Consultee Comments for Planning Application 21/00669/FUH

Application Number: 21/00669/FUH

Address: Fairways Drayton Lane Drayton Bassett Tamworth Staffordshire B78 3TS

Proposal: Erection of perimeter metal railings and electric sliding gates.

PROPOSED SECURITY FENCING & GATES TO PROPERTY FRONTAGE at "FAIRWAYS", DRAYTON LANE, DRAYTON BASSETT, STAFFS B78 3TS (SCALE 1: 100)

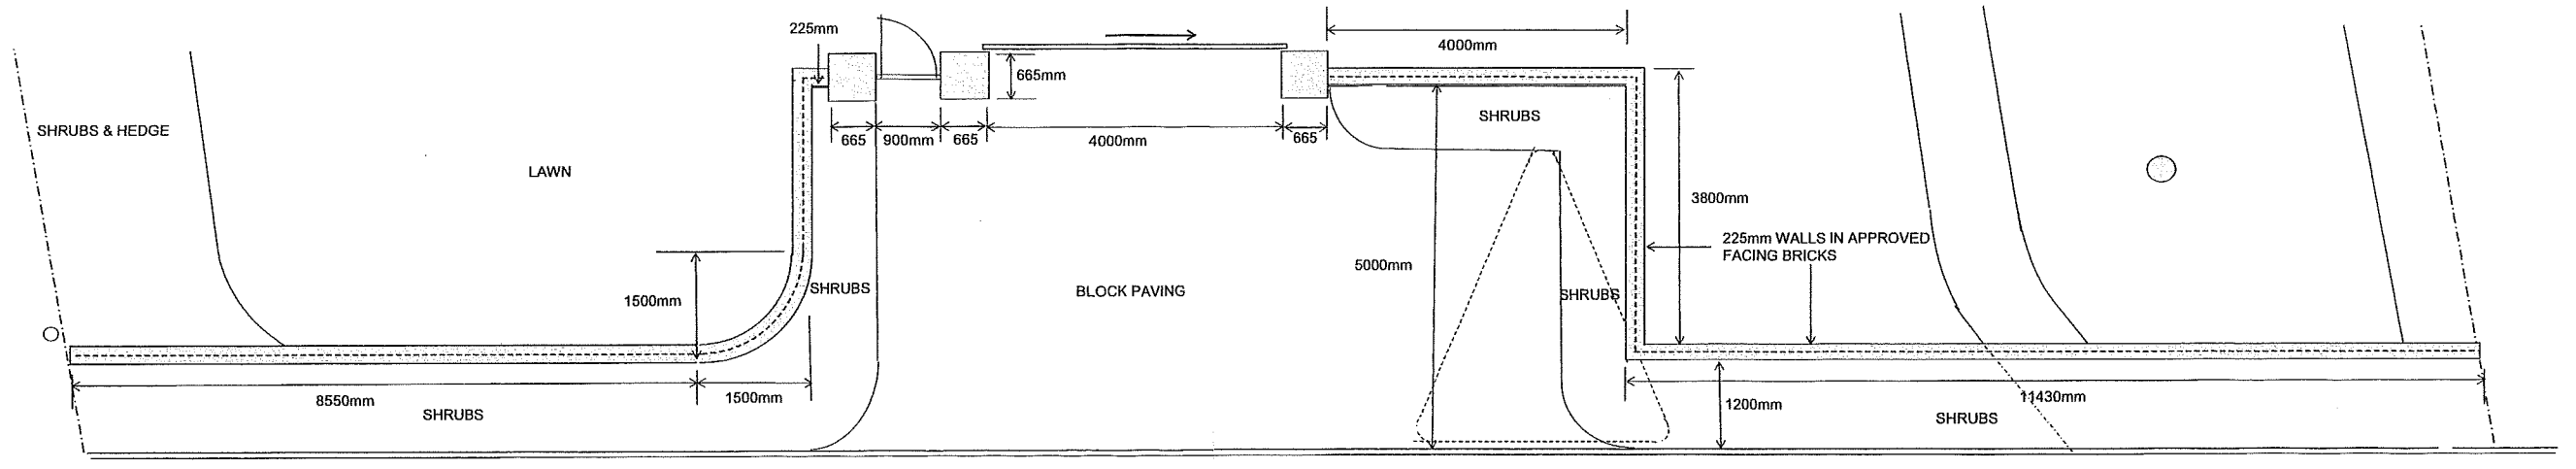
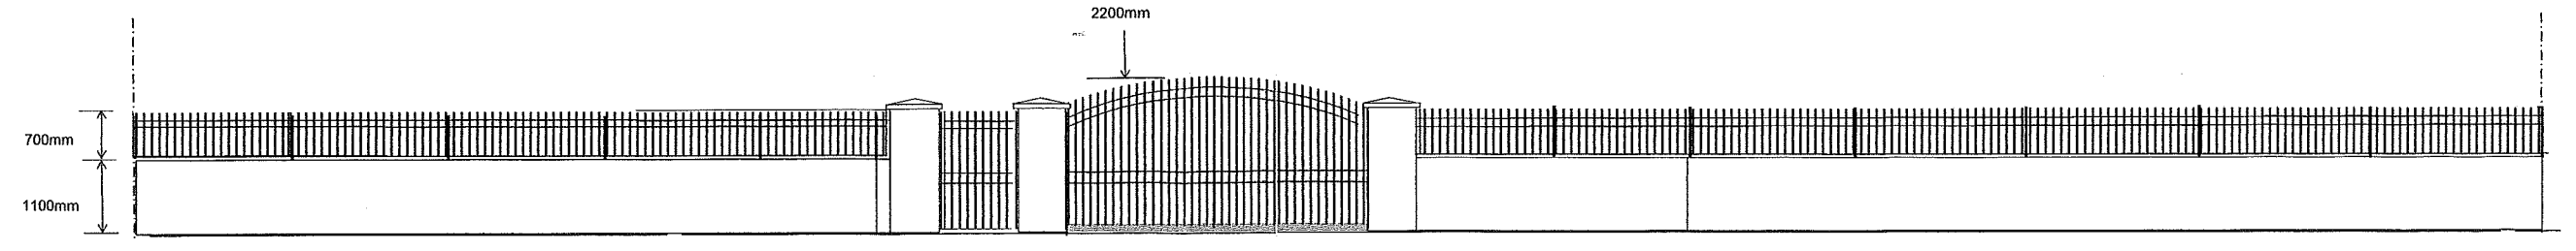
Drayton Bassett Parish Council object to this application. It is not in keeping with other gates/fences etc in that location, it is too obtrusive to the open plan nature of surrounding gardens, at 1.8m that close to the road.

Also the impact on mature trees needs to be considered.

Another point that I would like make is the lack of footpath in Drayton Lane, gardens at this moment extend beyond hedgerows, which may or may not be their boundary, if the fence is that close to the road it will reduce the margin of safety that pedestrians enjoy at this moment.
